TRANSPORT & URBAN PLANNING PTY LTD

1 June 2015

Re: Proposed QuarryWEST Masterplan
Response to Submission
Traffic Issues

QUARRY WEST ESTATE
RECONCILIATION RD, PEMULWUY
CONCEPT INTERSECTION LAYOUT
RECONCILIATION RD & BELLEVUE CCT

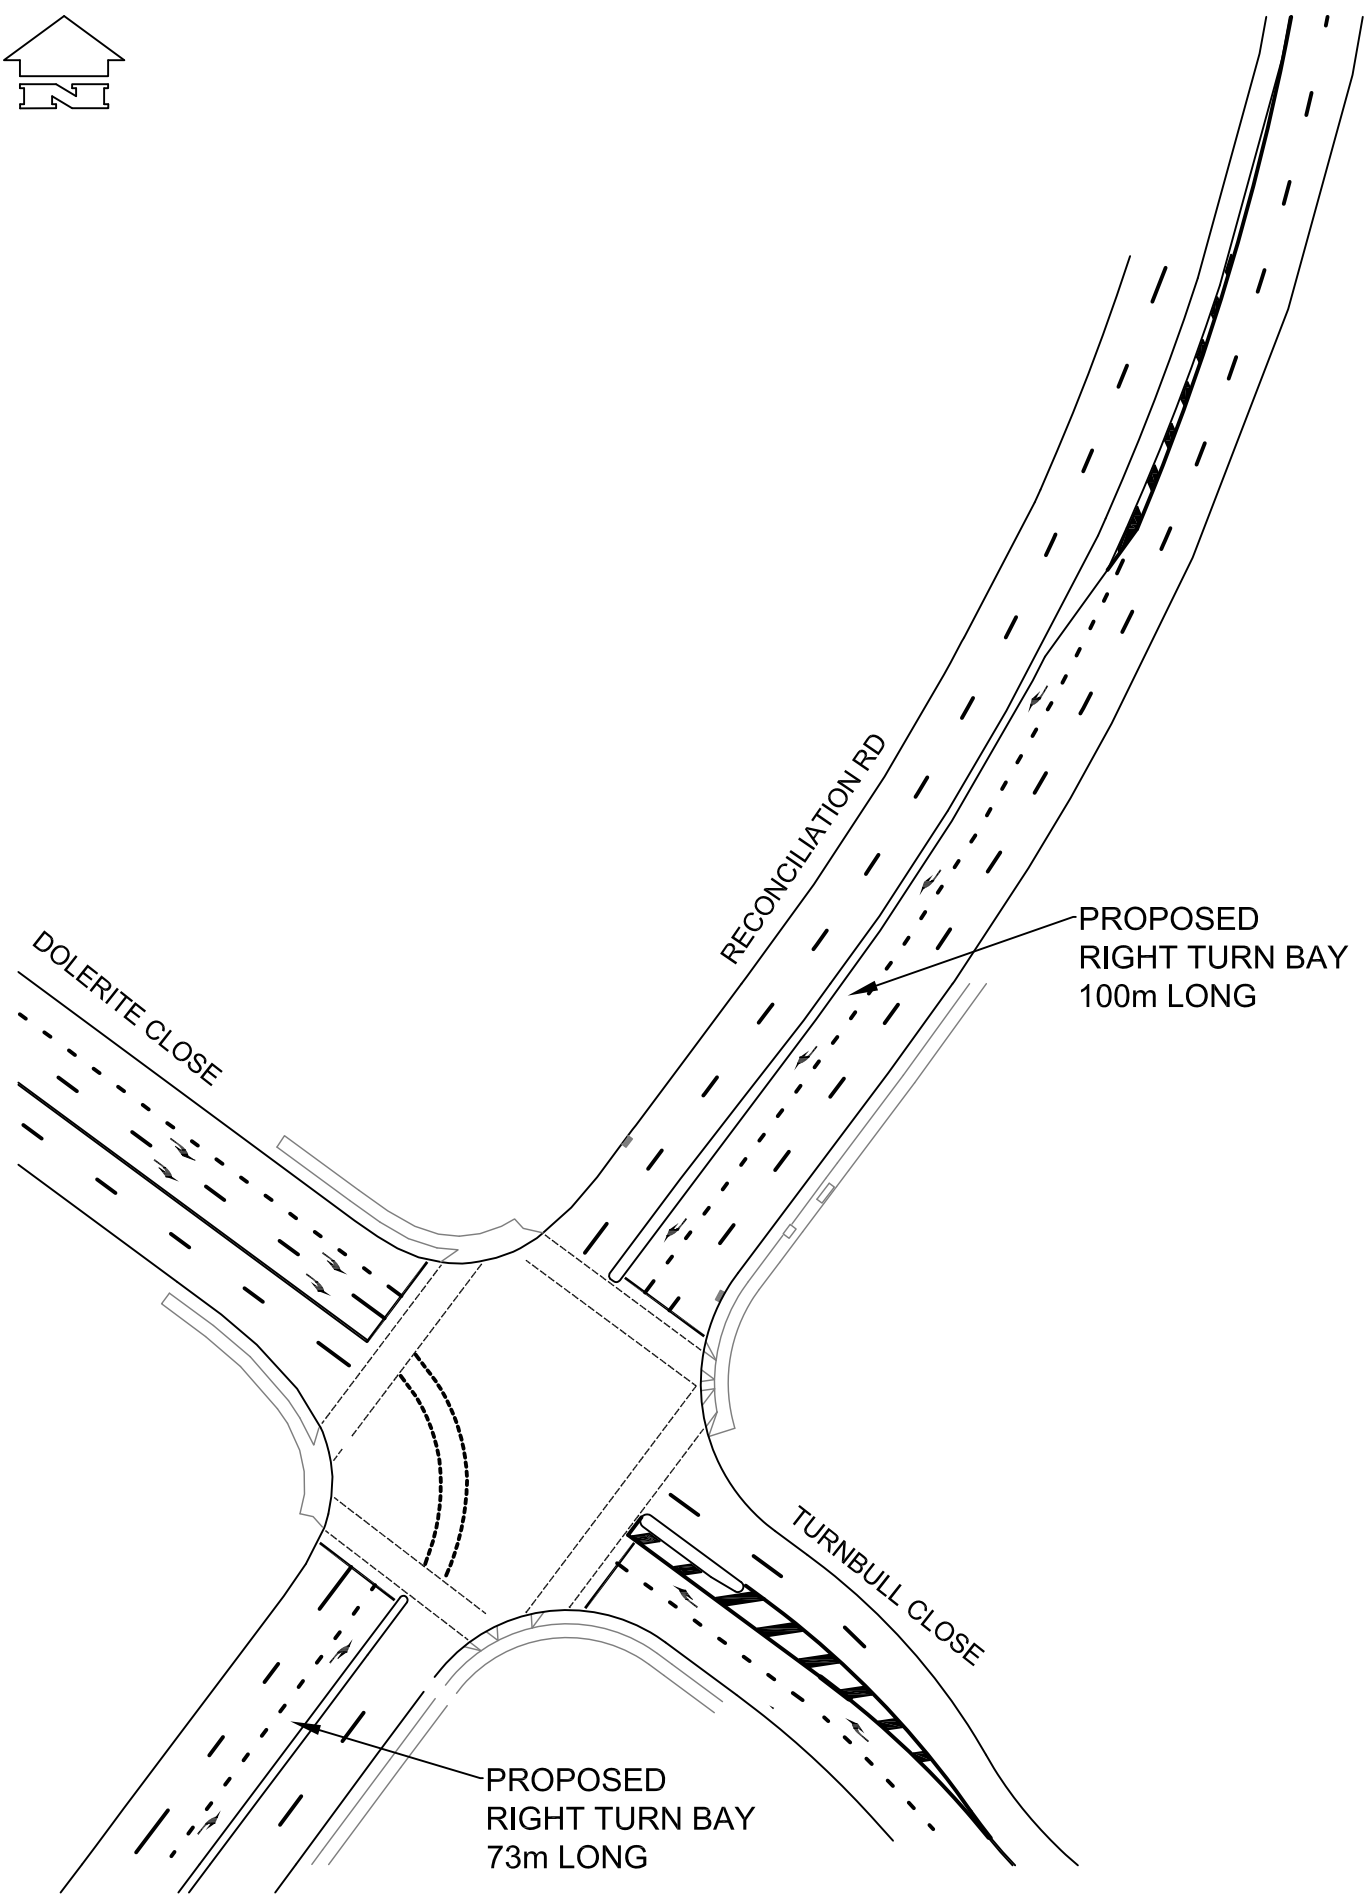
Issue 1 The layout of the existing intersection of Prospect Highway (Reconciliation Road) and Bellevue Cul De Sac has some issues i.e. no right turn bay in northern approach of Prospect Highway (Reconciliation Road), traffic signals and street lighting will need to be relocated, the design of the intersection shall be to RMS requirements.

Response: It is agreed that the intersection will need to be redesigned and incorporate a right turn bay in the northern approach of Prospect Highway (Reconciliation Road) and street lighting and traffic signal hardware will need to be relocated. Also the intersection will need to be designed to RMS standards.

FIGURE 12 A

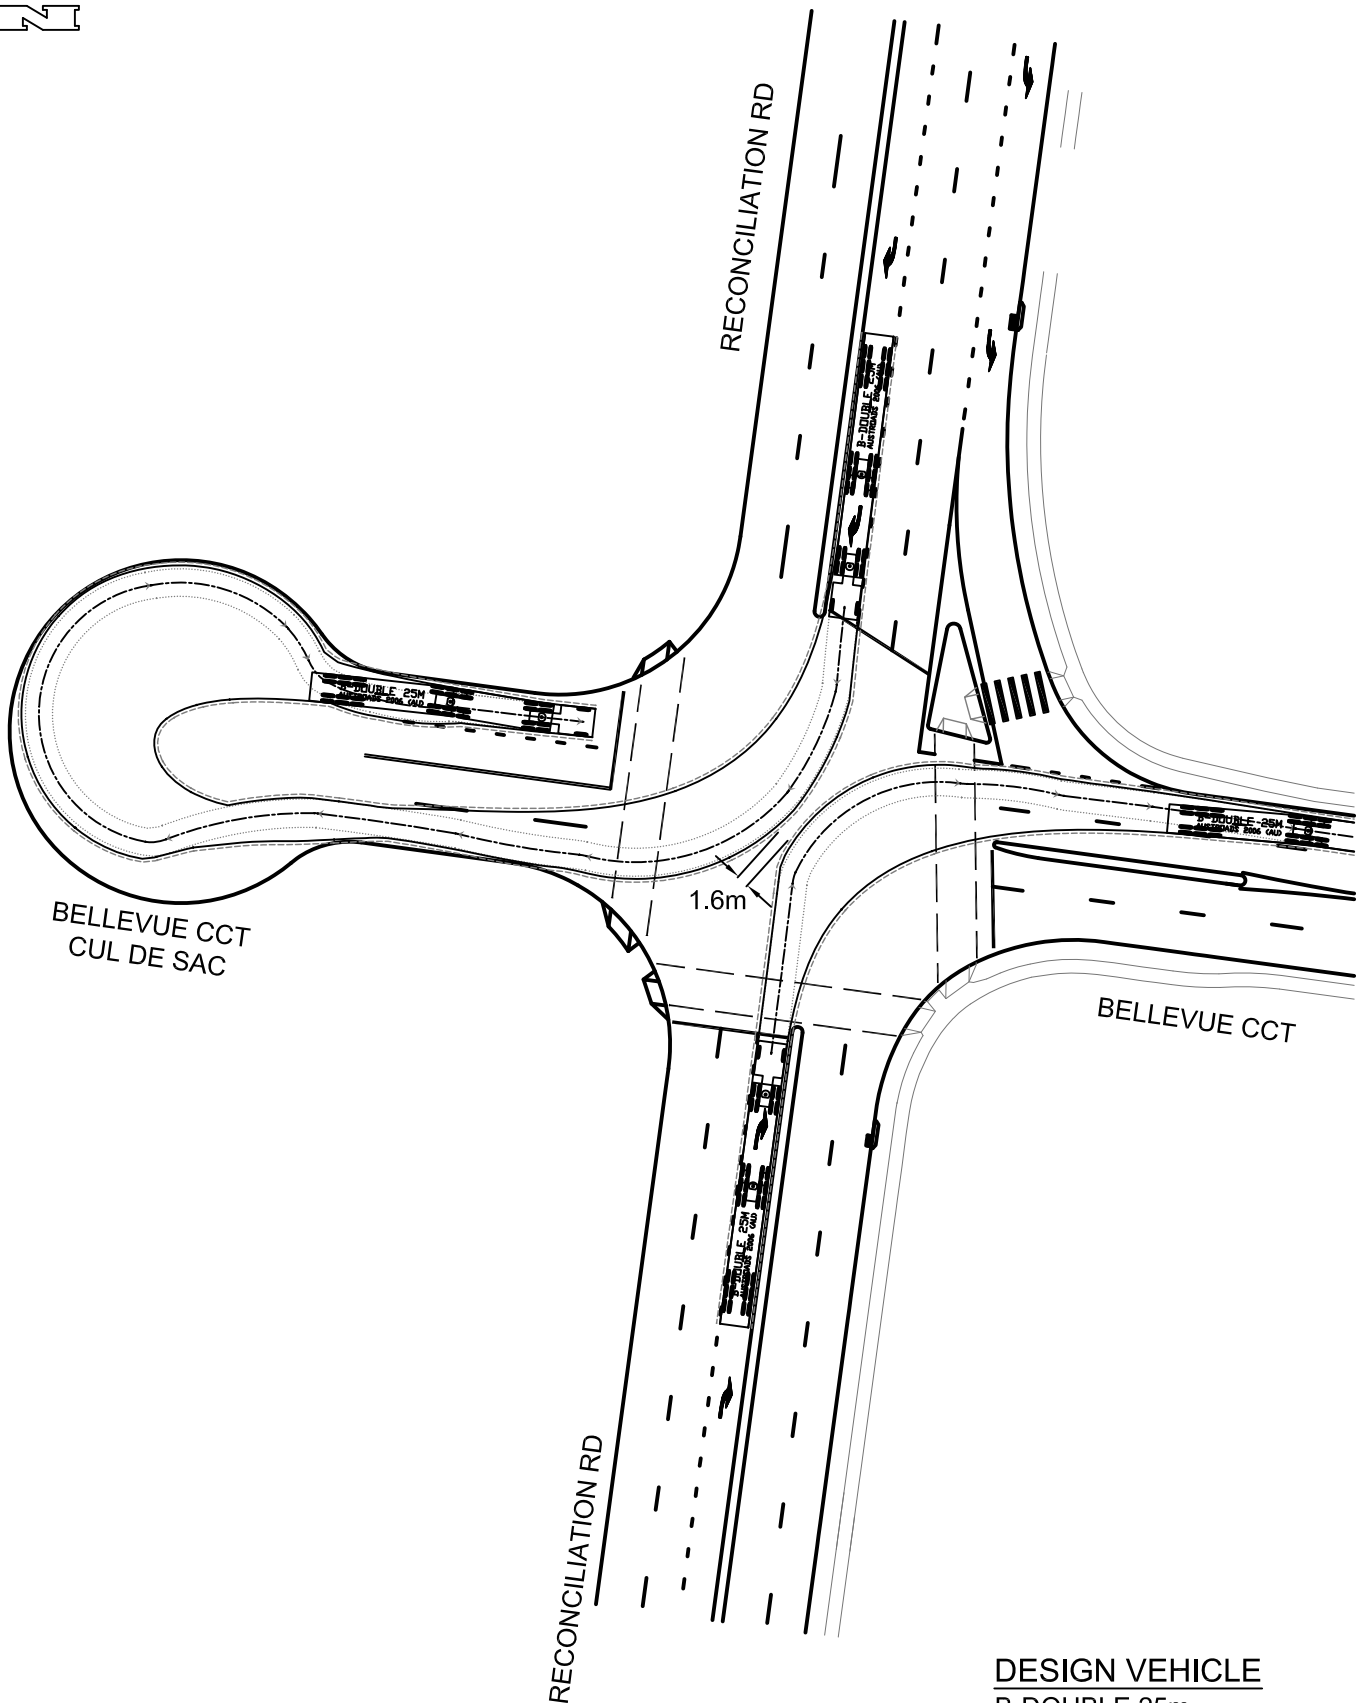
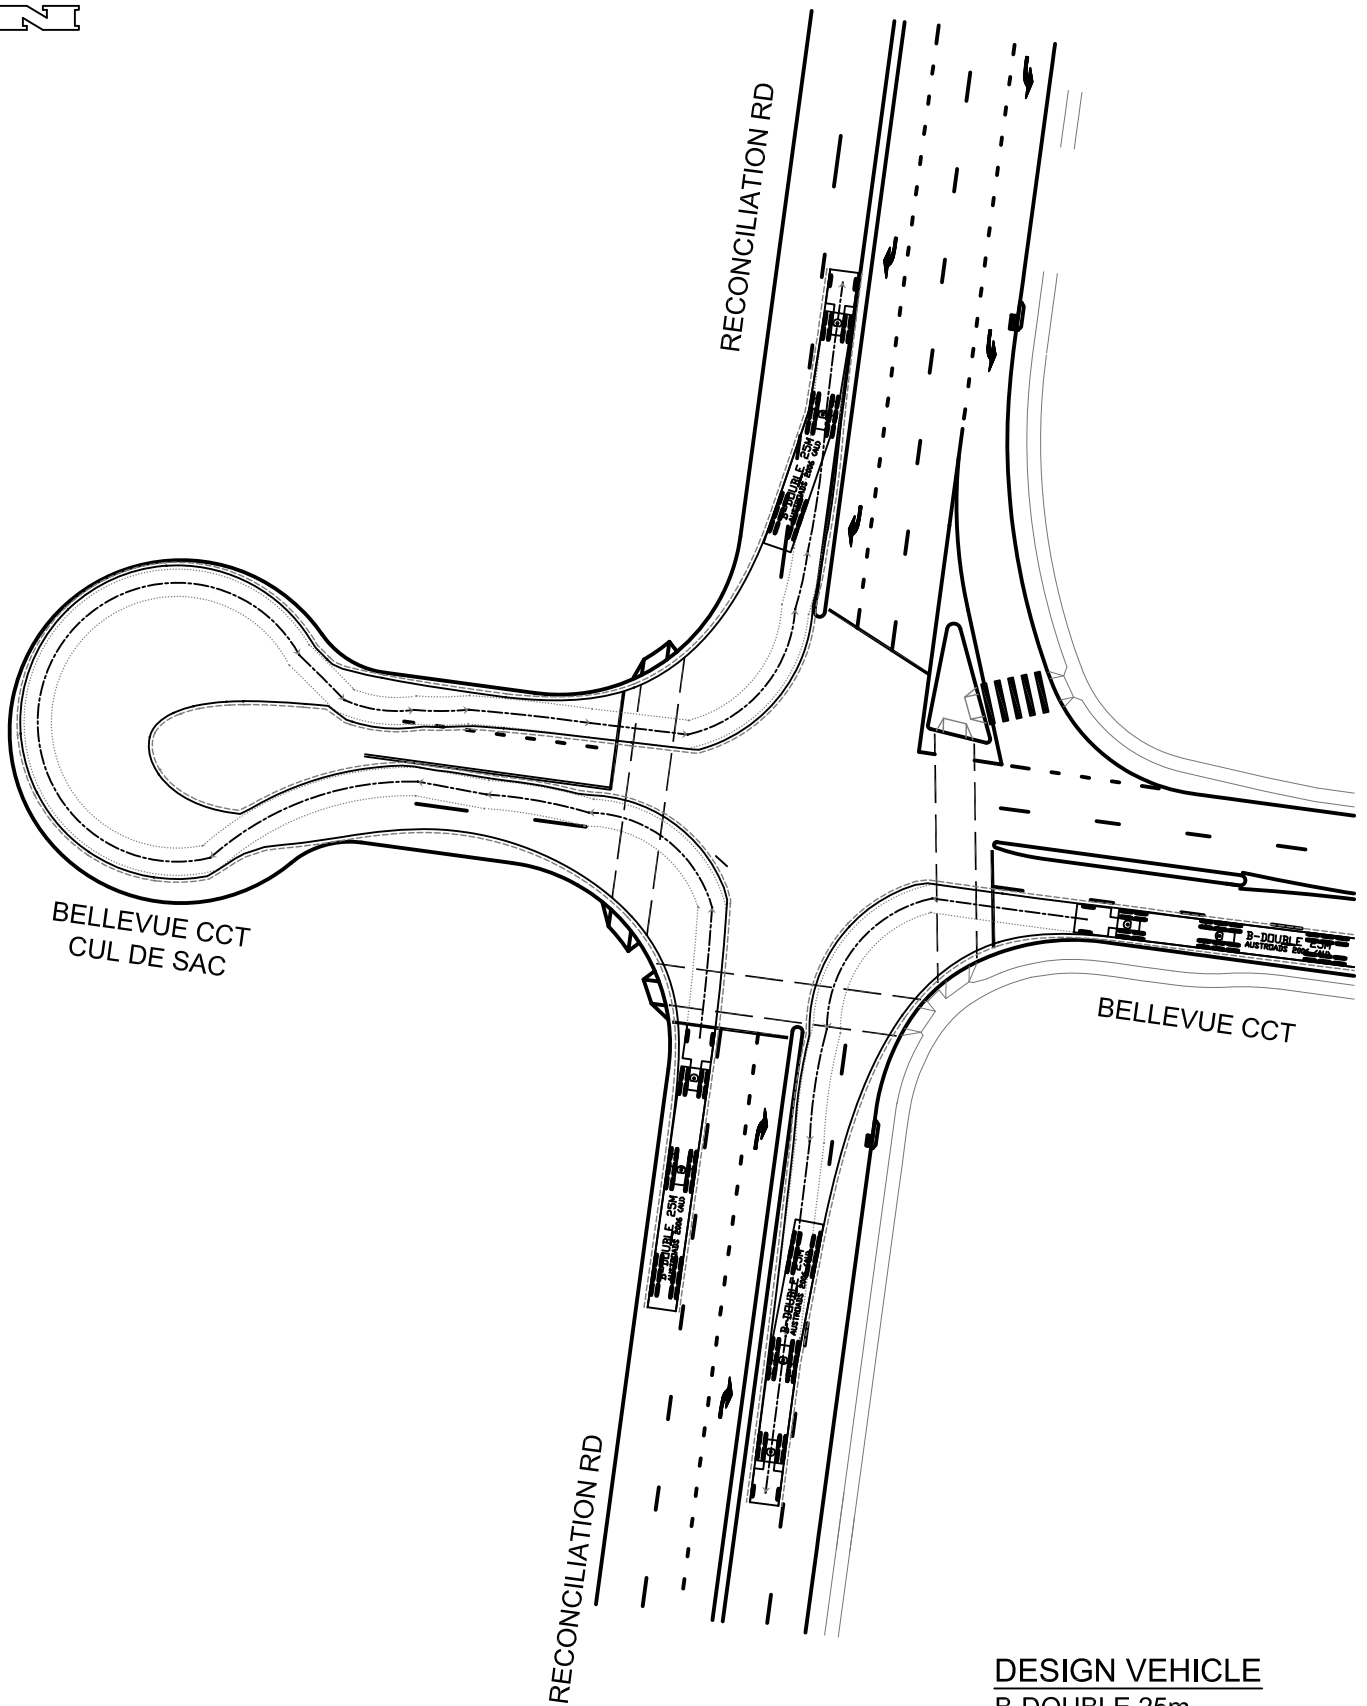
Issue 1. Design Heavy Vehicles. It would be prudent to adapt the turning path of a vehicle PBS Level 2B (i.e. up to 30 metres in length) to test the largest vehicle combination likely to access the development in the foreseeable future.

Response: Prospect Highway (Reconciliation Road) is an approved 25 metre B Double route. Vehicles that are up to 30 metres long currently do not operate in the Sydney Area. It is understood from discussions with Department of Transport officials that these longer vehicles possibly could operate within the Sydney area at a future time, subject to regulatory approvals.

Transport and Urban Planning Pty Ltd has sourced details of a 32 metre long Super B Double and tested the swept path of this vehicle for the left and right turning movements into and out of the QuarryWEST Estate Roads at Prospect Highway (Reconciliation Road) (i.e. Bellevue Circuit Cul-De-Sac and Dolerite Close) and at the internal roundabout of Dolerite Close/Basalt Road.

The swept path diagrams are shown on **Figures 12A -12E**. Reference to these figures shows that these longer vehicles can negotiate these intersections in accordance with relevant Austroads requirements.
